10 December 2020

SSI-10040 - PROJECT ENERGY CONNECT (NSW – WESTERN SECTION)

I refer to your correspondence regarding the subject Application which was referred to Transport for NSW (TfNSW) for assessment and comment.

Figure 4.1 Prospective haulage routes within the traffic and transport study area

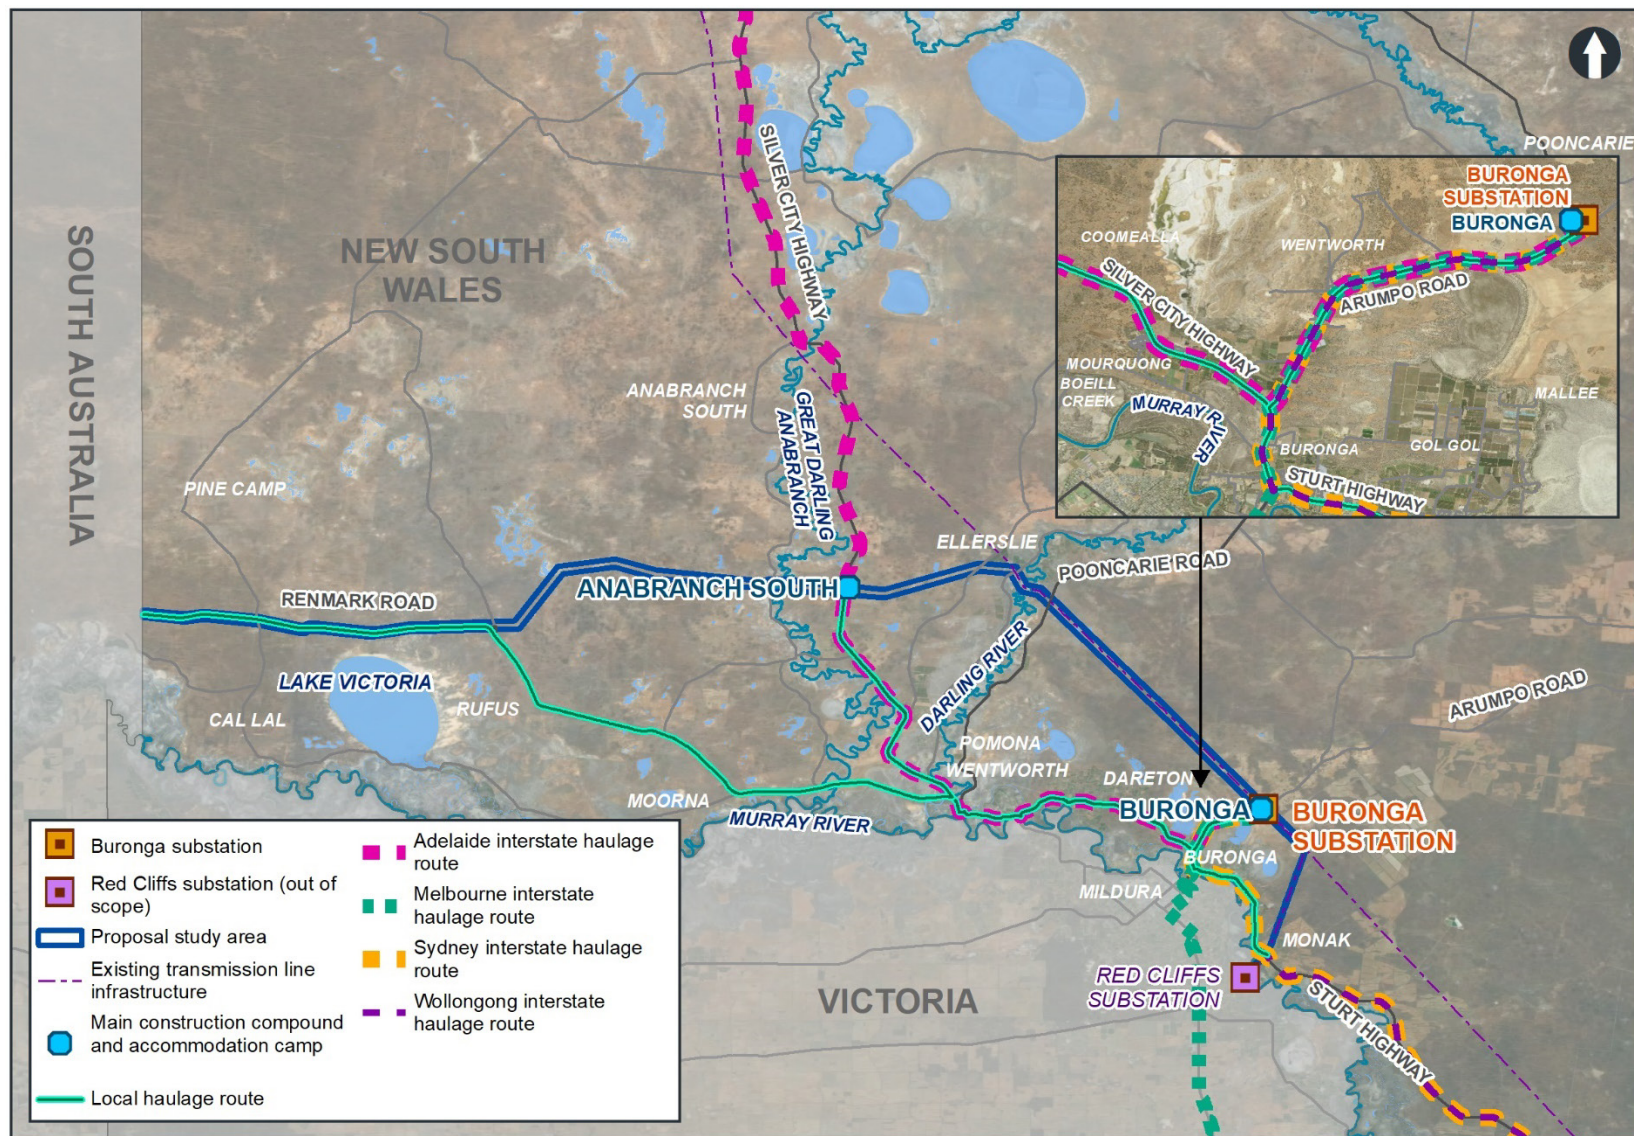
Section 18.4.5 refers to the potential haulage routes however the submitted documentation provides limited information in relation to the number and size of the oversize and overmass (OSOM) vehicles required to deliver components, including substations. The documentation lists four potential haulage routes depending on the port of origin of the components, including from Melbourne and Adelaide. The information provided does not currently address details of potential pinch points and specific mitigation measures required. More detailed information is required to allow for an informed assessment of the potential impacts on the road network.

The logistics associated with the transportation of materials for the development needs to be addressed. When the preferred haulage route is selected a full and independent risk analysis and inspection of the route may be required to be prepared and supplied for comment. Further analysis and reporting to assess possible damage to, and repair of the route will be required on a regular basis.
